09/04/2021

**St Marys Resource Recovery Facility (Borg) (SSD-10474)
Response to submissions**

Attachment 1

01 EXISTING SOUTH ELEVATION
SCALE: 1:100 (A1)

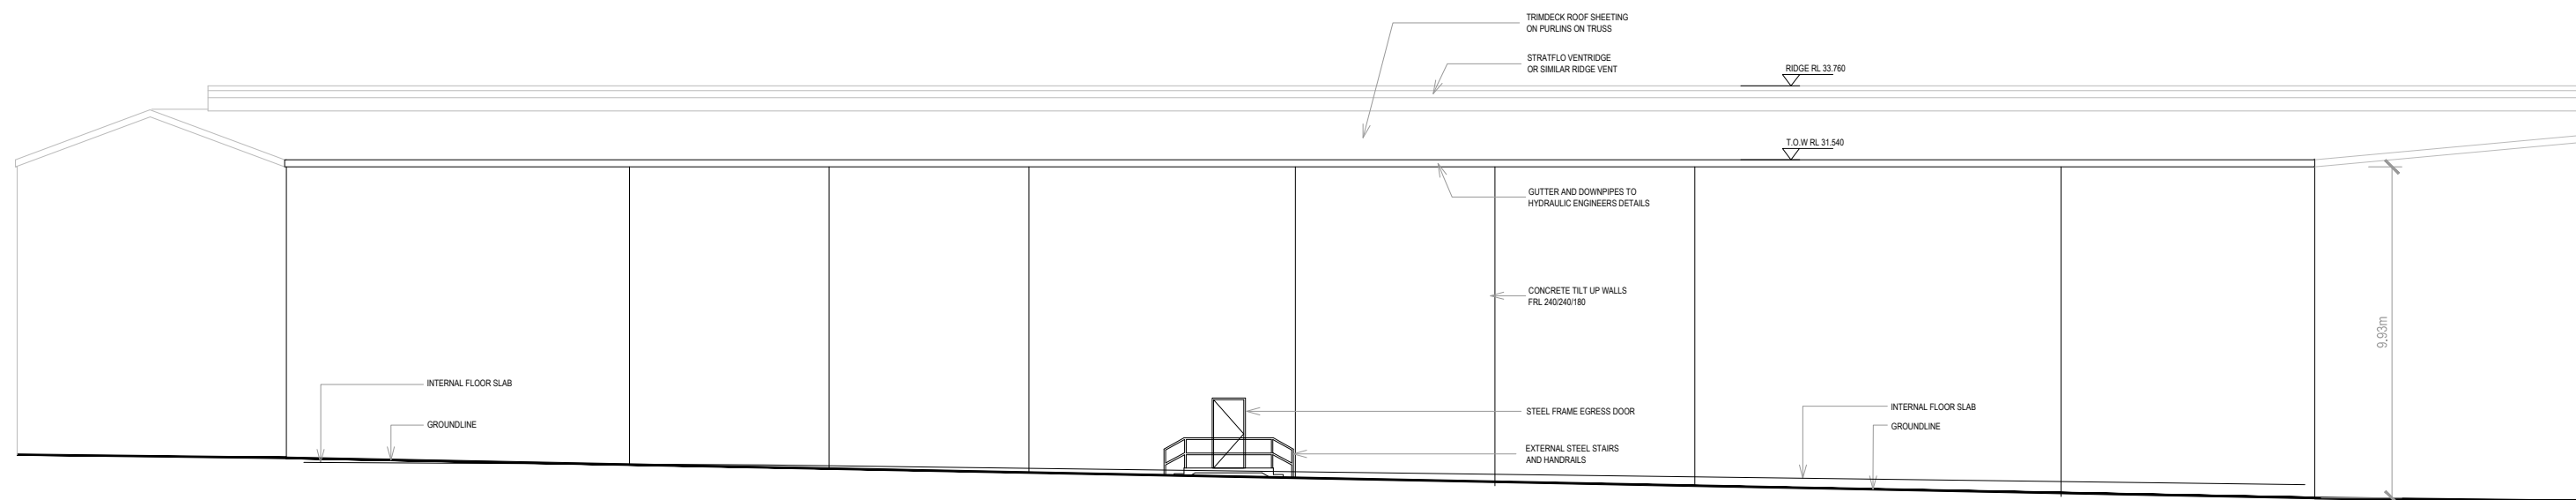
- Please clarify whether the Air Quality Impact Assessment considered emissions from open roller doors and the roof ridge vent.
- Please clarify whether the receipt and storage of potentially wet plasterboard would result in any unacceptable odour emissions.
